**Re: Aloft Hotel at 1515 Aircraft Ave. SE
Erosion and Sediment Control Plan – M15E057 – (SWQ-2025-00060)
Engineer’s Stamp Date: 10/24/25**

Based on the information in your submittal received on 10/25/25, the ESC Plan can't be approved until the following comments are addressed.

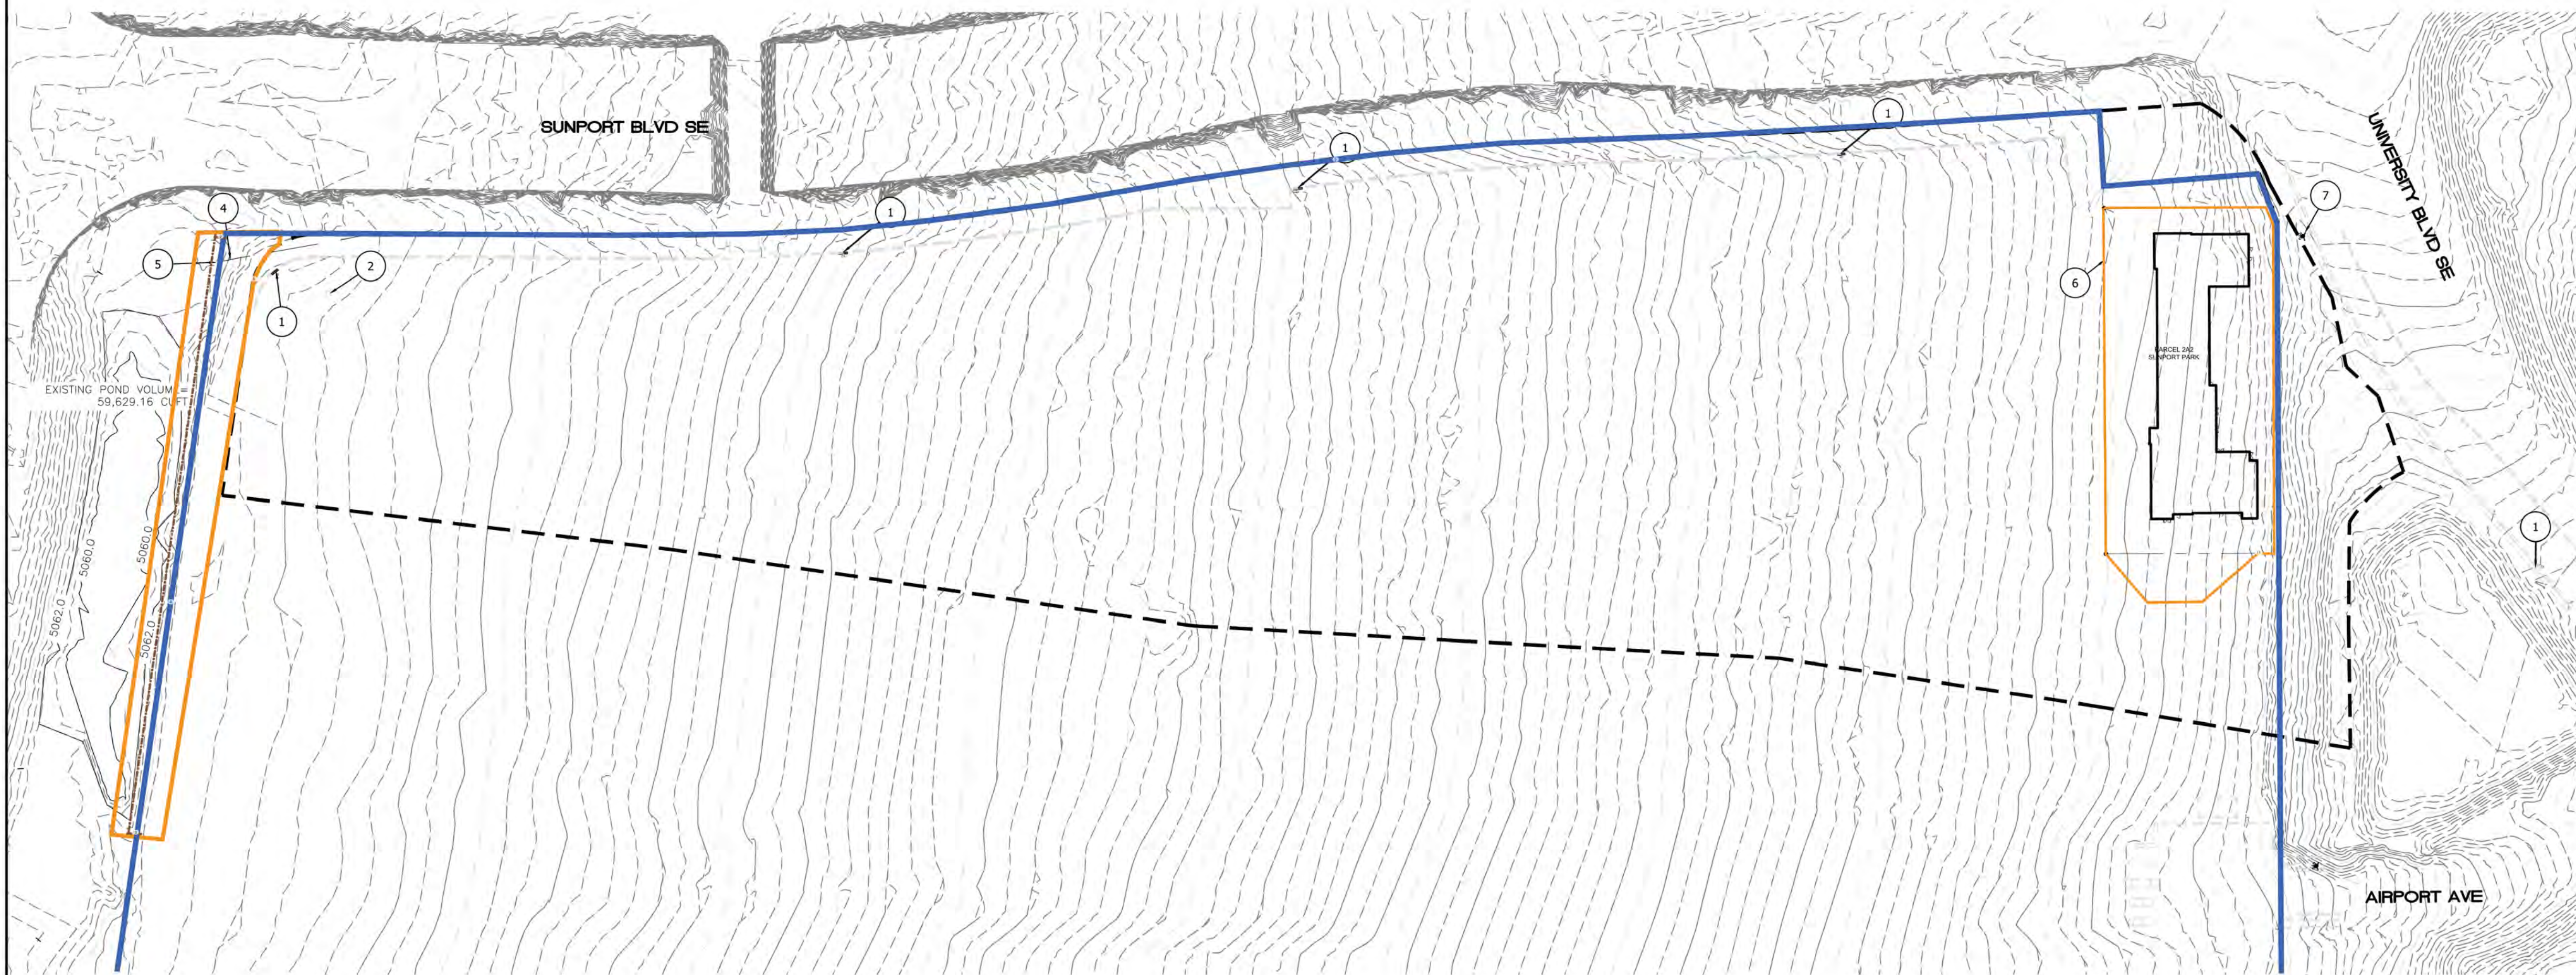
1. The *limits of disturbance* aren't located at the limits of grading as indicated by the proposed contours. Resolve the discrepancy between the contours and the *limits of disturbance*. The property owner's ESC Plan, Stormwater Pollution Prevention Plan (SWPPP), and NOIs are required for all land-disturbing activities prior to the City issuing any construction permits for this project. Phased construction is encouraged, and the area shown may be one of the phases, but the plan must identify adequate controls and Property Owner's NOIs as necessary to complete the project.

3. The proposed contours on the emergency access road east of the hotel show 15' of excavation on top of the existing city-owned dam, which will result in excessive off-site stormwater entering the Hotel construction area with the removal of the dam. For example, the proposed 5155 contour on the road crosses the existing 5170 contour atop the dam. The proposed contours don't tie into existing contours, leaving a 15' high slope unaccounted for. The limits of disturbance can't be identified until the proposed contours are tied into the existing contours. Submit a revised G&D Plan showing the corrected contours to Hydrology for approval, then submit a revised ESC Plan to the SWQ Section in ABQ-PLAN with the corrected contours.

6. A properly installed Stormwater Silt Fence (SWSF) or a properly sized and anchored Compost Filter Sock (CFS) will suffice at the west limits of disturbance for the first phase per sheet 4 of the ESC Plan, as it is level and “on contour.” The ESC Plan must specify a 24-inch diameter CFS if embedded SWSF isn’t used downgradient from the land-disturbing activity. Since the west edge of the proposed contours isn’t level, it does not meet the design specifications for either Silt Fence or Compost Filter Sock. Therefore, a combination of a temporary Diversion Channel and Sediment Trap is required along the west edge of the proposed contours.

7. I can’t distinguish between building, sidewalk, asphalt, and dirt on the ESC Plan. Construction specifications for these structures must be clearly identified in the SWPPP per CGP 7.2.4.b.vi. The same information is required in the ESC Application. You may attach a copy of the Site Plan to both the SWPPP and the ESC Application to meet this requirement.
